From: Mat Holland [REDACTED]
Sent: 23 June 2011 18:30
To: Janice Chapman
Subject: [Mailwall-Spam:]re: p/37/11 - rear storage building and car port at 64 st

Title : Proposed South & East Elevations
Address : 64 St Thomas Drive, Pagham.
Date : 05,04,11
Scale : 1:100
Dng.No : PE06

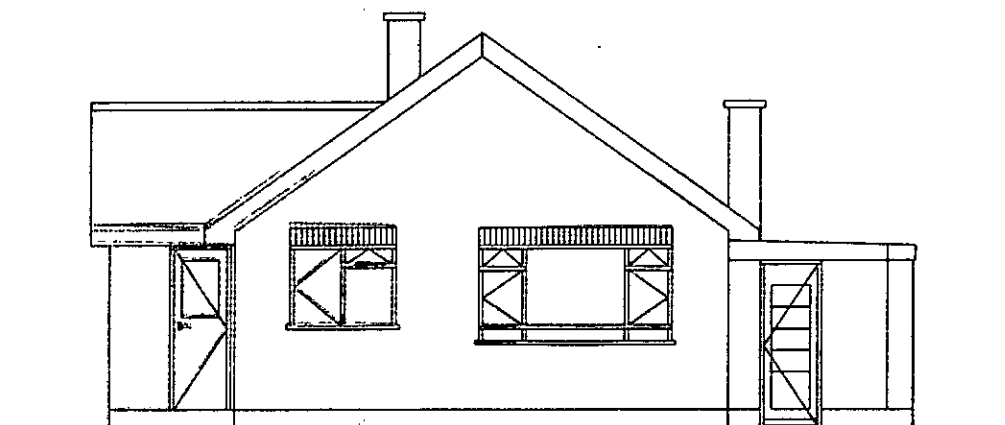
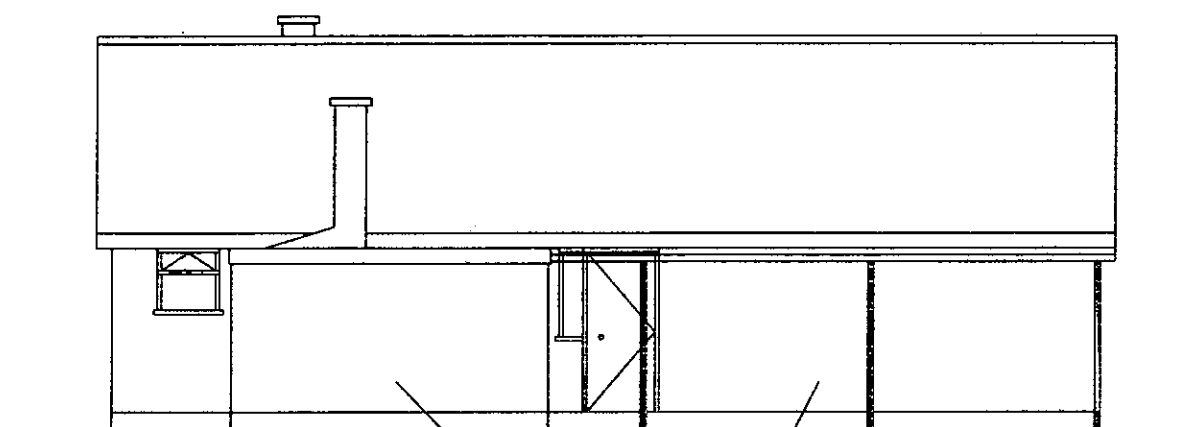
The proposed car port does not extend beyond the front wall.

The store roof covering green mineral finish, car port roof to be poly-carbonate translucent.

Car port to be supported by the boundary fence posts or 70mm diameter metal poles sleeved by plastic.
